RE: Intake Screening - 2112-184– 9017 SE 60TH ST, MERCER ISLAND
Blueline Job No. 21-377

This letter is in response to your review of the 9017 SE 60th St project. The plans have been revised per the comments in your letter dated 1/4/2022. Below is a list of each comment with our responses in bold.

6/1/22  
 JOB NUMBER:  
**21-377**  
 SHEET NAME:  
**SP-01**  
 SHT **4** OF **5**

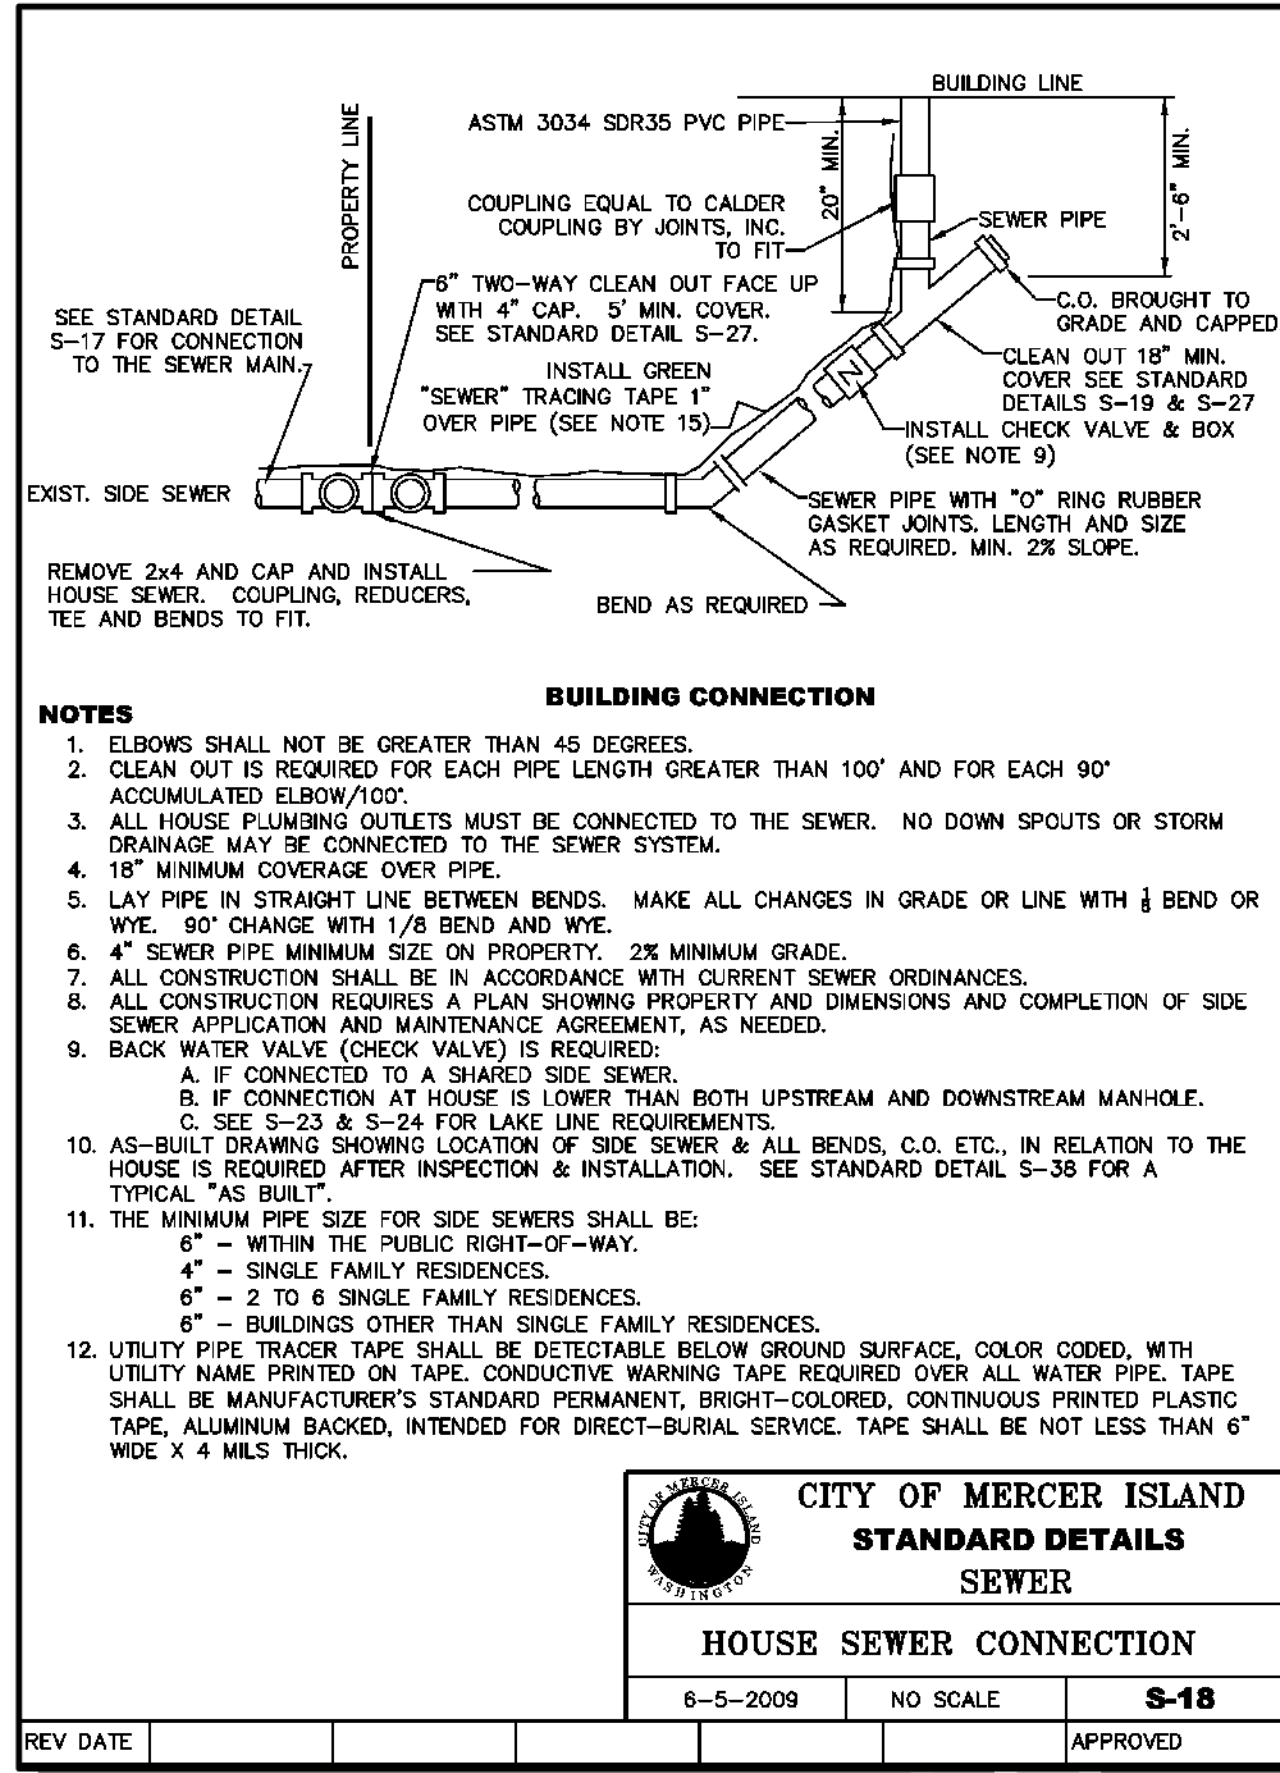
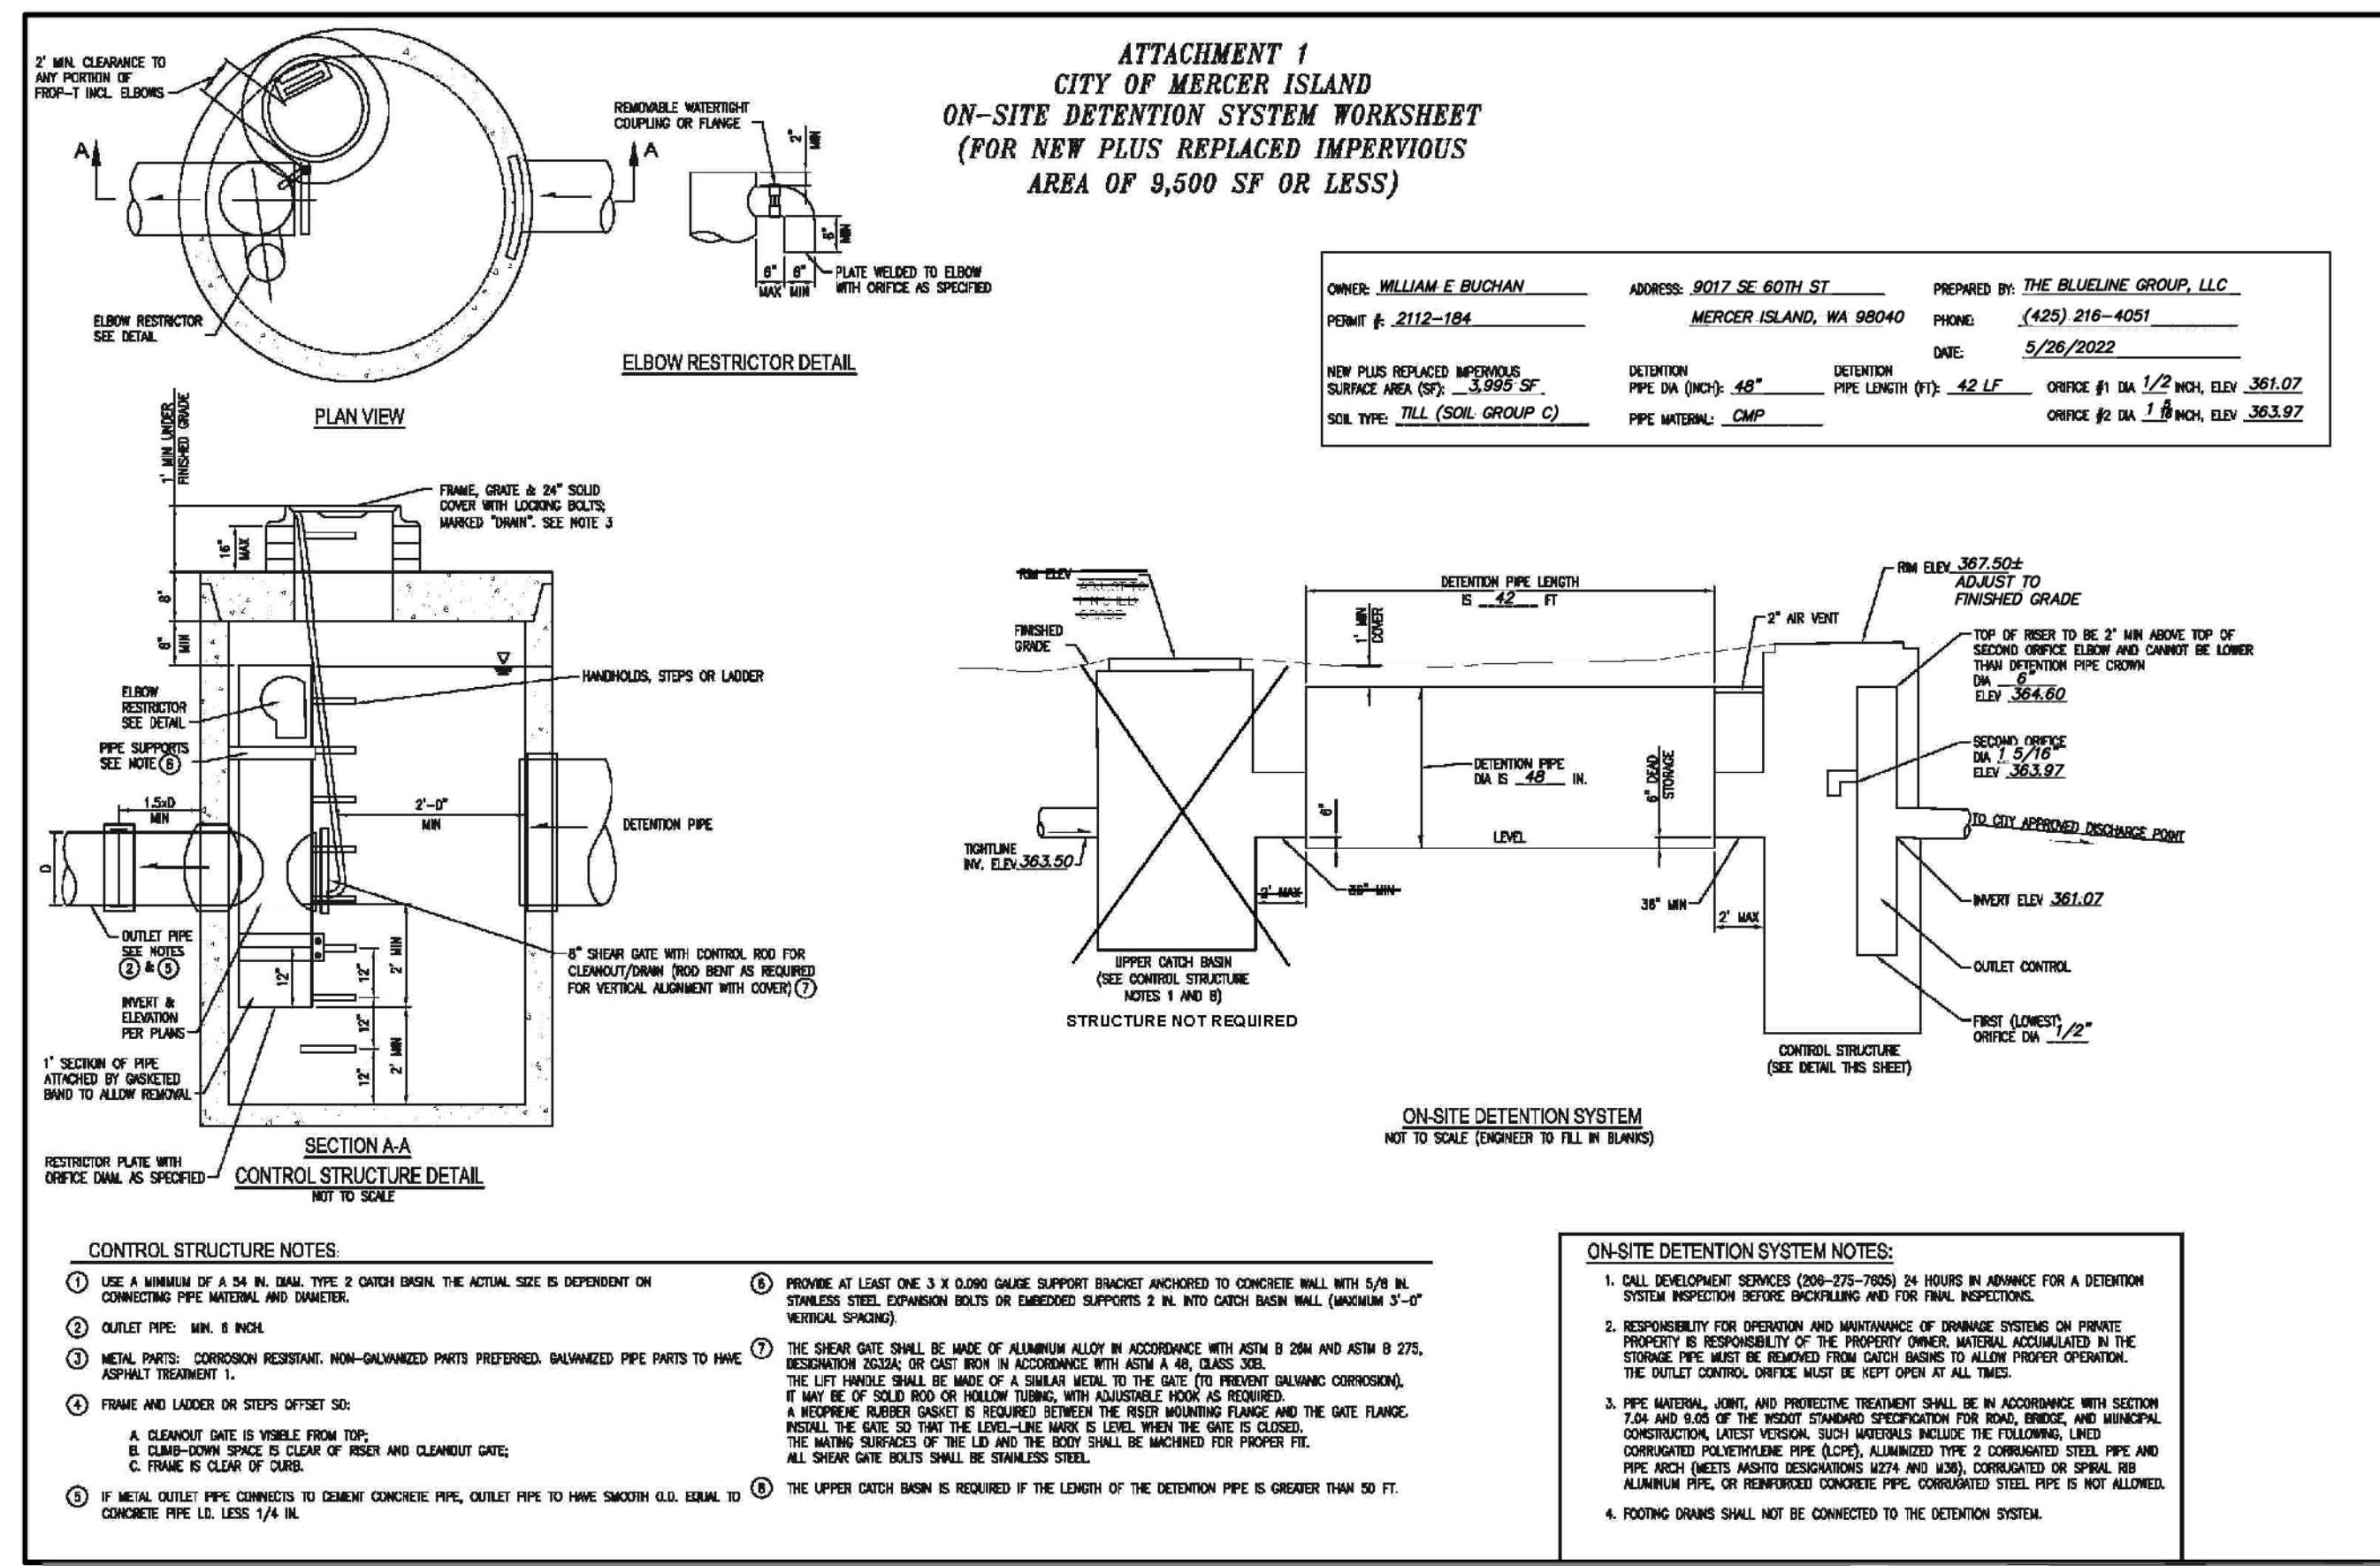
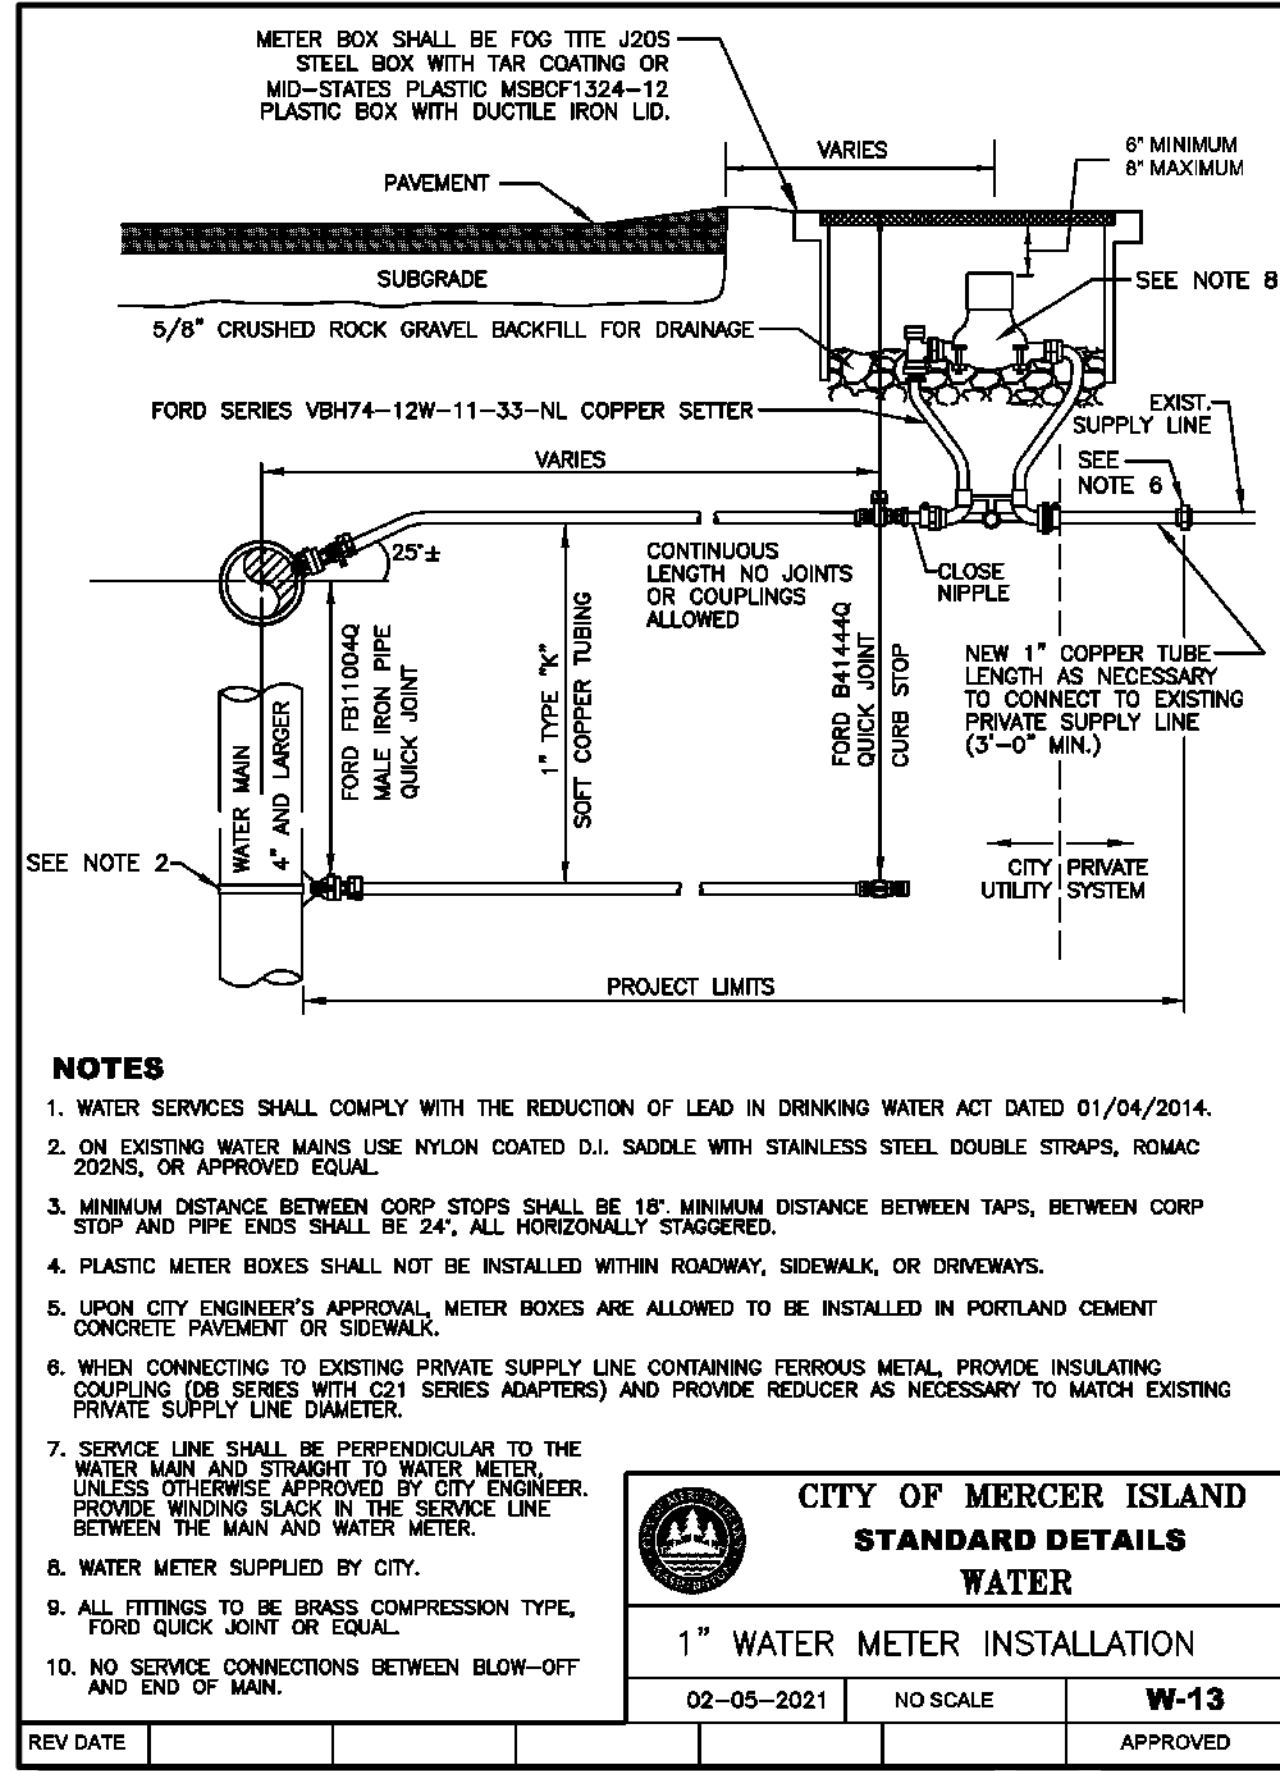
2. The drainage design for the driveway will need to be designed to meet MICC 15.09.

A trench drain was proposed at the property line to capture driveway runoff and convey flows to the detention tank.
